City of Westminster

Date: 13 January 2014

Proposed Application for a Development Consent Order (DCO) by Thames Water Utilities Limited, for the Thames Tideway Tunnel (the application).

This is the City of Westminster's written representation, in regard to second written questions, in relation to proposals for development at Victoria Embankment Foreshore. We are working with other affected Local Authorities to prepare appropriate project wide requirements and views on mechanisms for securing undertakings and assurances given in the DCO and supplementary agreements.

Figure 1.1 Victoria Embankment Foreshore: Site context and location plan

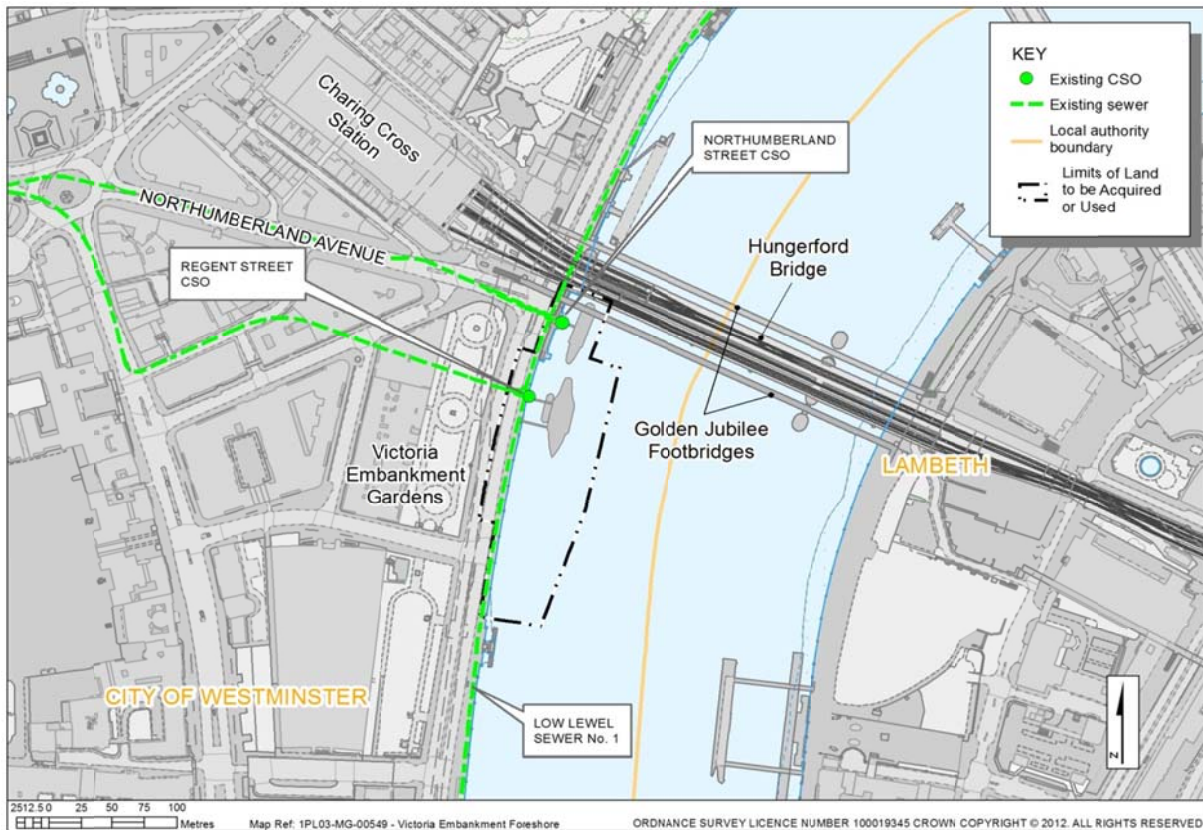
The main designated heritage assets affected by the new foreshore structure including the relocated Tattershall Castle are the grade II listed Embankment Wall; the grade II listed Royal Air Force Memorial; and the Whitehall Conservation Area. The effect of the proposal will be to introduce greater intrusion onto the foreshore creating a more cluttered embankment. The new foreshore structure is located approximately where the Tattershall Castle is currently located and so the design solution proposed by the applicants is to move the Tattershall Castle further upstream.

This re-positioning will come in two phases, with it being positioned further upstream during the construction phase (closer to the RAF Memorial) and then moved closer to the foreshore structure in the operational phase. In both phases the re-positioned Tattershall Castle will be an additional structure projecting into the foreshore, where at present the listed embankment wall is relatively clean of any clutter (eg. see plates 11.4.13, 14, 38, 39, 40 and 41 of Townscape and Visual Assessment doc ref.6.2.17). As an additional structure in this location it will create a more cluttered townscape, obscuring and eroding the clean line of the embankment wall and encroaching upon the setting of the RAF Memorial which at present is appropriately clear of any riverside structures. By compromising the setting and appearance of these listed structures the proposal is also considered to cause harm to the character and appearance of the conservation area.

In both the construction phase and the operational phase, the re-positioned Tattershall Castle will be visible in views looking east from Horse Guards Avenue. At present this view, which is flanked by the grade I listed Ministry of Defence to the right and the grade II* Whitehall Court to the left, is terminated by the river, with the silhouette of the embankment wall clearly defined and the 'gap' of the river behind, with the Southbank in the distance. This view and this part of the City are considered to be positive contributors to the character and appearance of the conservation area. The encroachment of the Tattershall Castle into this view will disrupt the silhouette of the listed wall and this is considered to have a detrimental impact on this townscape and cause harm to the conservation area.

In both the construction and the operational phase the brows linking the vessel to the Victoria Embankment will be physically attached to the listed wall, causing some permanent harm to the structure, but more significantly they will also create considerable visual clutter, which will be apparent when walking along Victoria Embankment. The structures will include two access brows, one of which features a long access ramp (approximately 23m in length) on the

highway and one will feature a canopy over it. Given the location of existing trees (to be retained) the space between the access stairs/ramps and the trees will be approximately 2.75m which, given that this is a significant and heavily used public promenade, will create a narrowed section of the highway, impeding pedestrian movement and a visually cluttered character and appearance.

The visual impact of such access ramps can be appreciated by reference to those at Savoy Pier (downstream) and Millbank (upstream). The ramp and stepped access points will also mean that this currently clean section of listed wall, with its uninterrupted views across the river, will be obscured, thus eroding the significance of the listed wall and the character and appearance of this part of the conservation area.

In terms of degree of harm caused, the construction of the new foreshore structure which will involve the demolition of a substantial section of the listed embankment wall and permanently interrupt the linear character of the wall is considered to result in substantial harm. In the case of the relocated Tattershall Castle, it is acknowledged that there will be less permanent physical alteration to listed fabric and as such it is considered that the harm caused to the affected listed structures and the conservation area could be regarded as less than substantial. Nonetheless the tests at paragraphs 133 and 134 of the NPPF should apply.
